RWE Renewables UK Solar and Storage Limited

Planning Act 2008 – Response to advice following issue of decision to accept the application for examination (Section 51 Advice)

Application reference: EN010139

On 8 March 2024, the Planning Inspectorate (PINS) issued a decision by the Secretary of State (SoS) to accept an application made by RWE Renewables UK Solar and Storage Limited (Registered Company No: 14539260) (the Applicant) for an Order Granting Development Consent for the Byers Gill Solar project (the Proposed Development).

Drawing Title  
**Street Works, Public Rights of Way & Access Plans**  
Sheet 1 of 13  
**APFP Regulation 5(2)(k)**

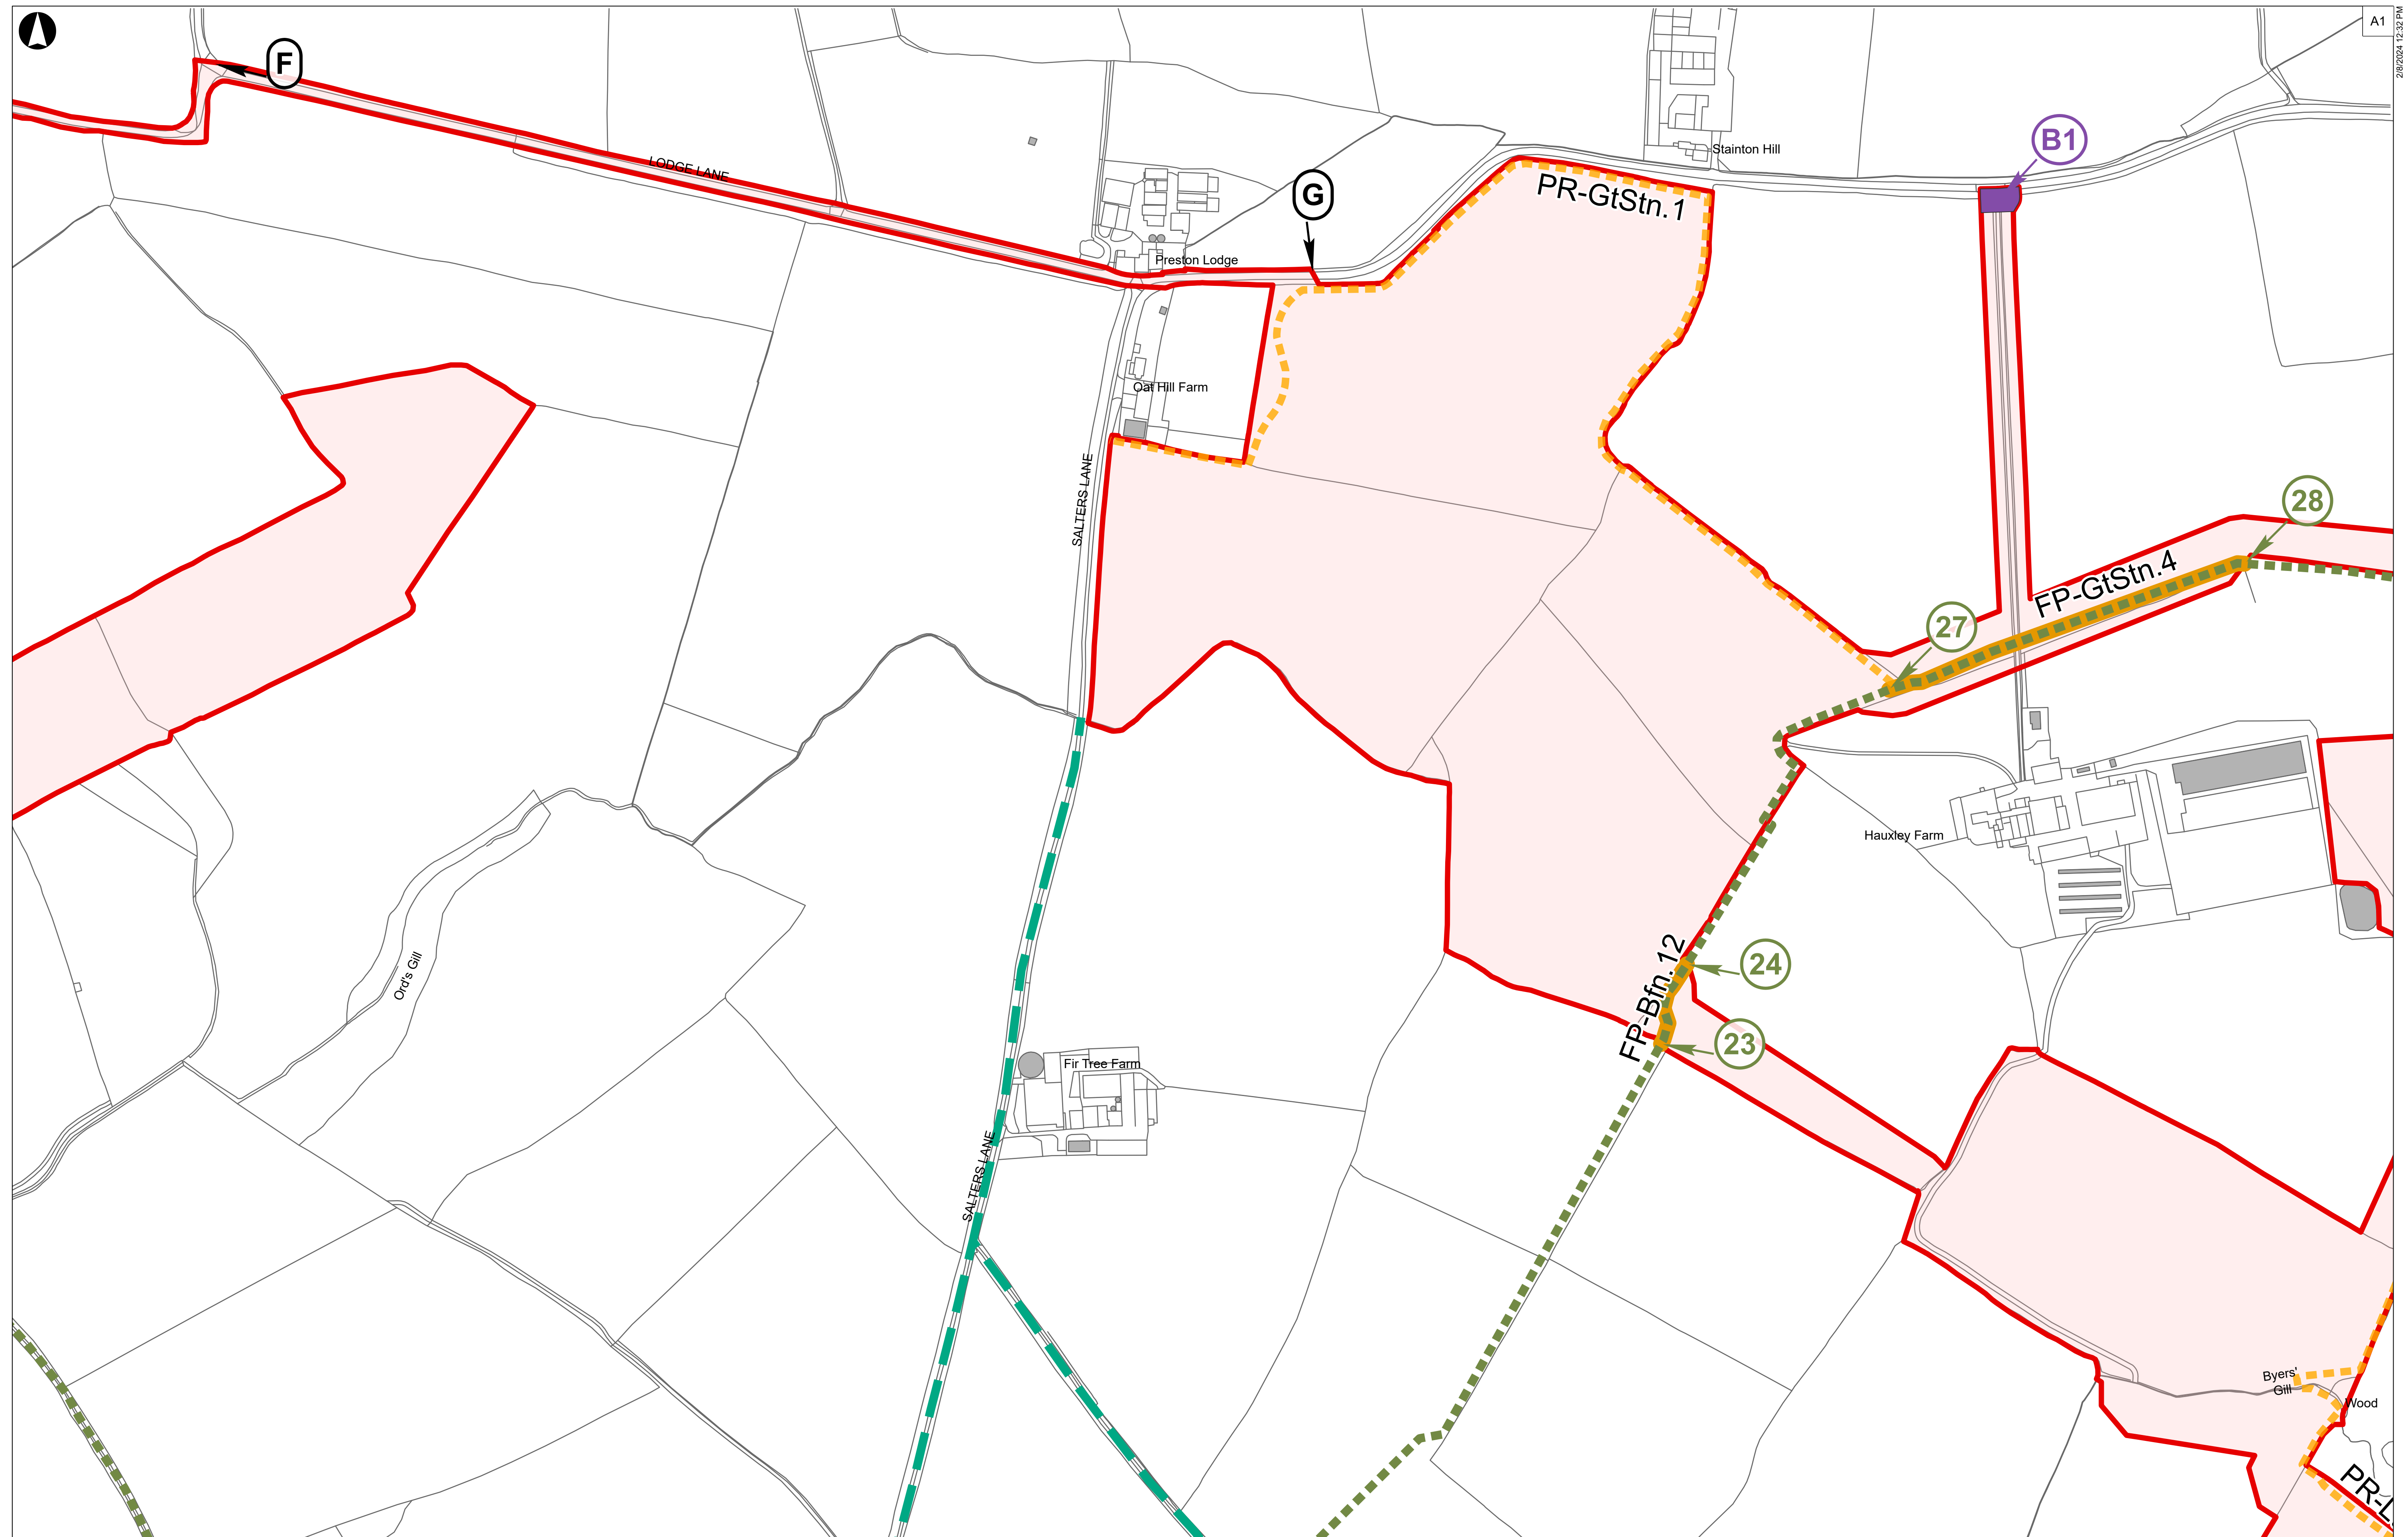
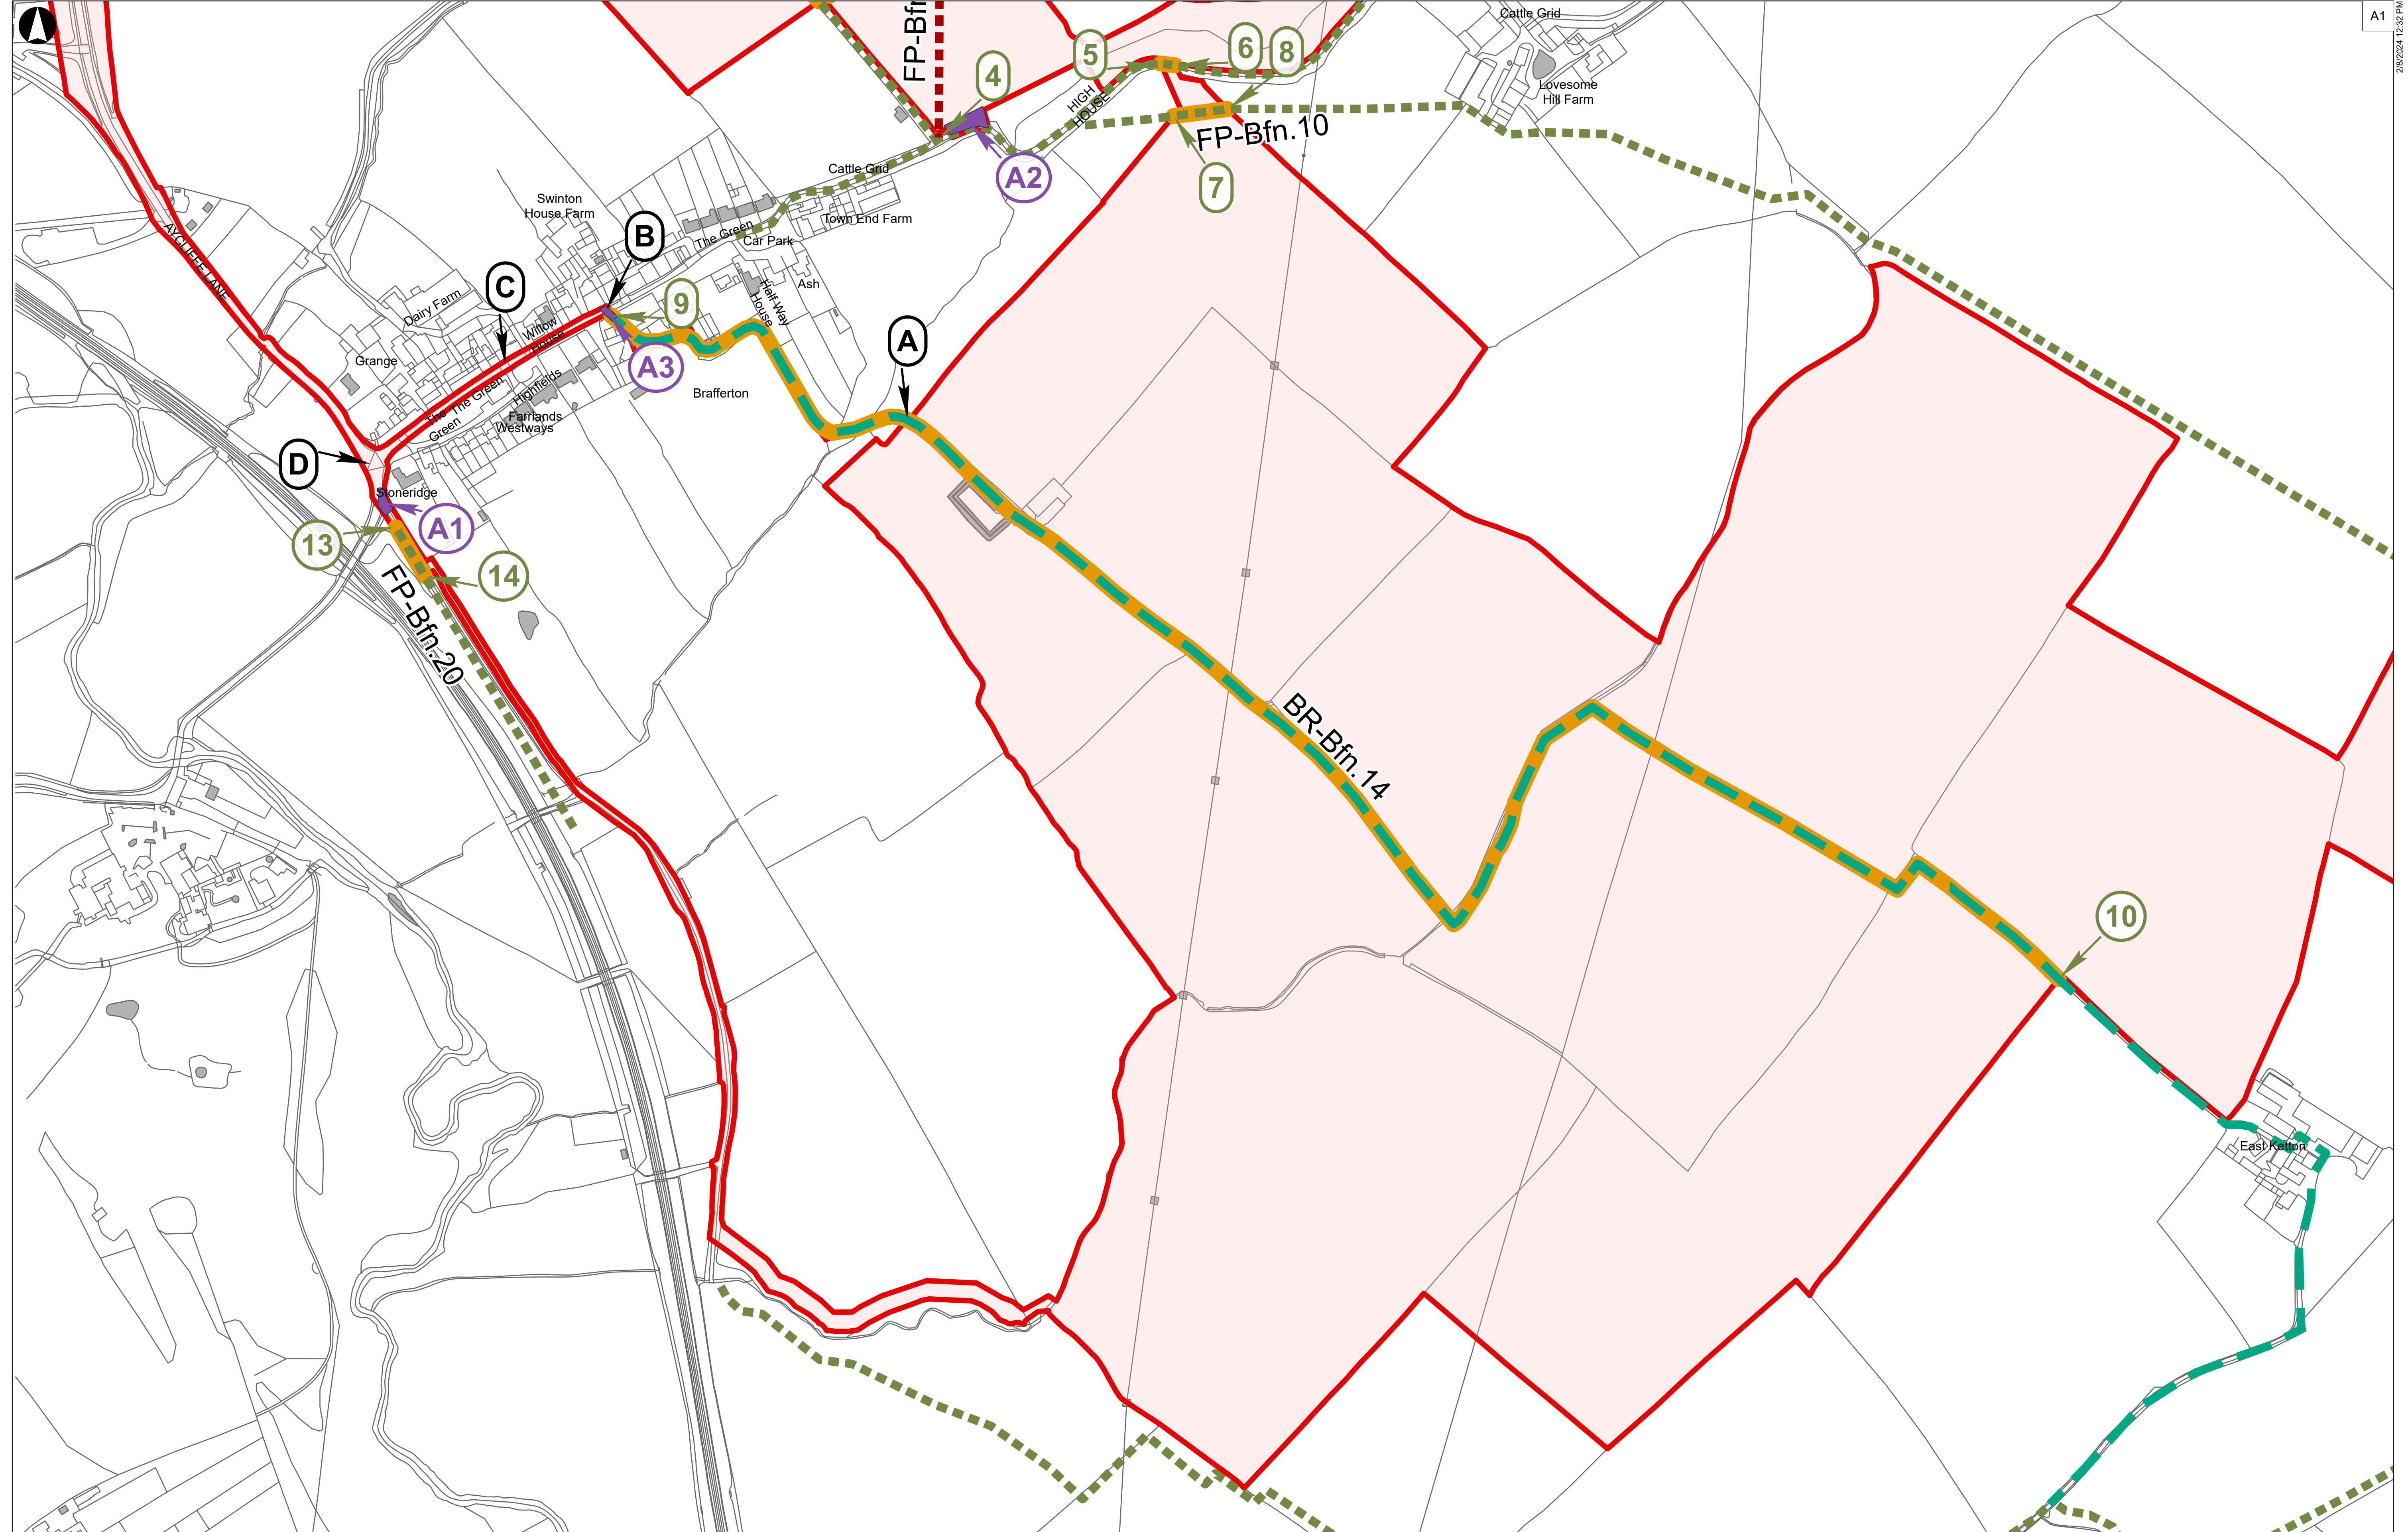
Advice	Applicant Response
<p>Street Works, Rights of Way and Access Plans (Doc 2.3)</p> <p>The Inspectorate notes that there appears to be a lack of consistency across the plan sheets regarding street names and additionally there are some named streets which are referenced in the draft Development Consent Order that do not appear to have been labelled on the plans, e.g. sheet 7 and 8, Elstob Lane. The Applicant may wish to review the Street Works, Rights of Way and Access Plans and amend to ensure consistency and that all roads listed are labelled across all plans. It has also noted that the legend is not consistent with the approach taken for the Land Plans in terms of listing only the details as reflected on the sheet. The key reflects various types of street works, even though the relevant sheet appears to not show the streets works as depicted in the legend. The legend on each sheet should be limited to what is present on that particular part of the plans; e.g. sheet 1, legend should not include 'A' streets subject to street works'. Consistency must be evident across all plans. The order of the sheets in the Street Works, Rights of Way and Access Plans is not consistent with that of the Key Plan included in the Works Plans (Doc 2.2) or the Land Plans (Docs 2.4). In addition, the Street Works, Rights of Way and Access Plans does not appear to actually match the layout of the key plan and does not appear to correspond to the order in which the sheets of the Street Works, Rights of Way and Access Plans are actually set out.</p>	<p>The Applicant acknowledges the inconsistencies identified by PINS in relation to the Street Works, Rights of Way and Access Plans (Document Reference 2.3). The Applicant has reviewed the advice provided by PINS and has produced a revised set of these plans, submitted alongside this letter.</p> <p>The amendments made to the plans under this revision seek to address the issues identified and have included:</p> <ul style="list-style-type: none"> • Updates to the key plan so that it is now consistent with the Works Plans (Document Reference 2.2) and Lands Plans (Document Reference 2.4). Please note that this change is to the order of the key plan only, and therefore does not impact on the Schedules of the dDCO which cross-reference these plans. • The Legend on each sheet has been amended so that it only shows what is visible on each individual sheet. • A review of the plan's labels against the dDCO Schedules has been undertaken and new labels added in so that they are more easily cross-referenced. <p>The revised plans (Revision 2) are provided to PINS to supersede those submitted at the point of DCO application.</p>
